City of Portland, Maine - Building or Use Permit Application
 389 Congress Street, 04101 Tel: (207) 874-8703, Fax: (207) 874-8716

Permit No: 03-1143	Issue Date: SEP 18 2003	CBL: 368 A014001
-----------------------	-----------------------------------	---------------------

Proposed Project Description:
 Build 8x10 wood frame shed

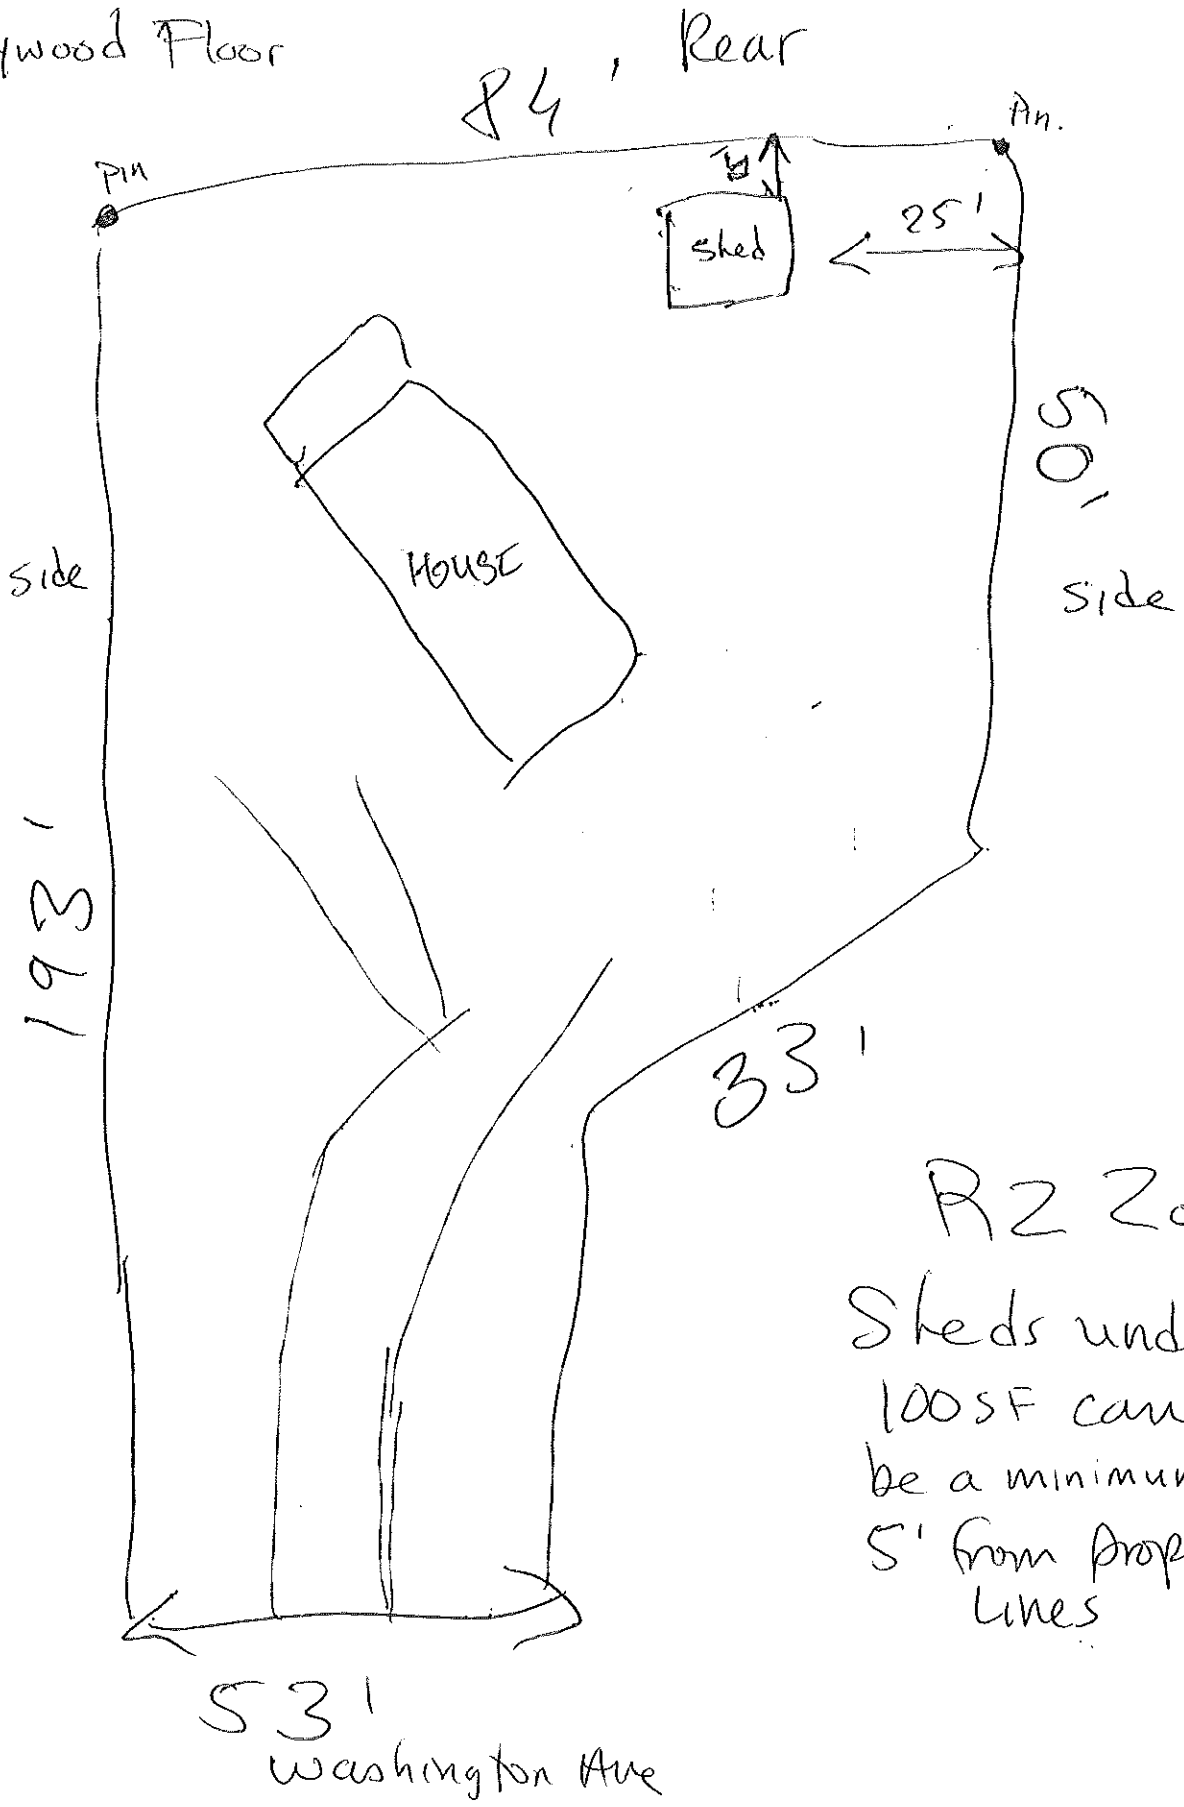
Dept: Zoning	Status: Approved	Reviewer: Jeanine Bourke	Approval Date: 09/18/2003
Note:			Ok to Issue: <input checked="" type="checkbox"/>
Dept: Building	Status: Approved	Reviewer: Jeanine Bourke	Approval Date: 09/18/2003
Note:			Ok to Issue: <input checked="" type="checkbox"/>
1) Roof must have minimum 2x6 rafters 16 O. C. And 1/2" plywood sheets Floor must have minimum 2x6 joists 16 O. C.
